Submission on the NorthConnex EIS (Environmental Impact Statement).

Department of Planning and Environment, Major Project Assessment, Attn: Assessing Officer, Application No SSI136136, GPO Box 39 Sydney 2001 or www.majorprojects.planning.nsw.gov.au

MOTORWAY OPERATIONS COMPLEX - SOUTHERN VENTILATION FACILITY - SECTIONS
M1-M2-5000-DR-JD-0525

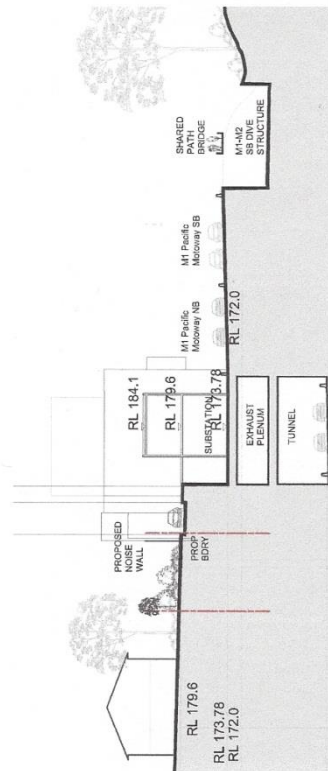
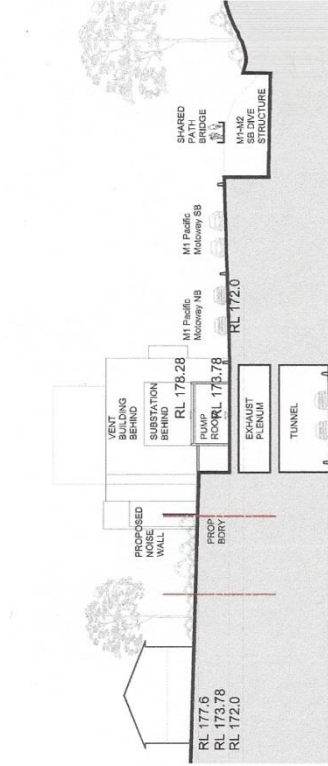
- The tunnel, 9km long, will not be filtered. Particles under 1 micron from diesel fumes are carcinogenic (cancer causing) and called the 'new asbestos' because their impacts take a long time to manifest. Concentrated emissions will come from the unfiltered stacks at the southern (near Pennant Hills Golf Club) and northern end (Wahroonga) and drift onto nearby residences and schools endangering the long term health of the community. Children are particularly vulnerable as they are growing. These stacks must be filtered.

- NorthConnex seems to believe that this highly carcinogenic and toxic pollution drifts upwards. Research shows it cascades down from the stacks and drifts on the wind over surrounding neighbourhoods. No modelling has been conducted in the areas of these stacks to assess emission drift.
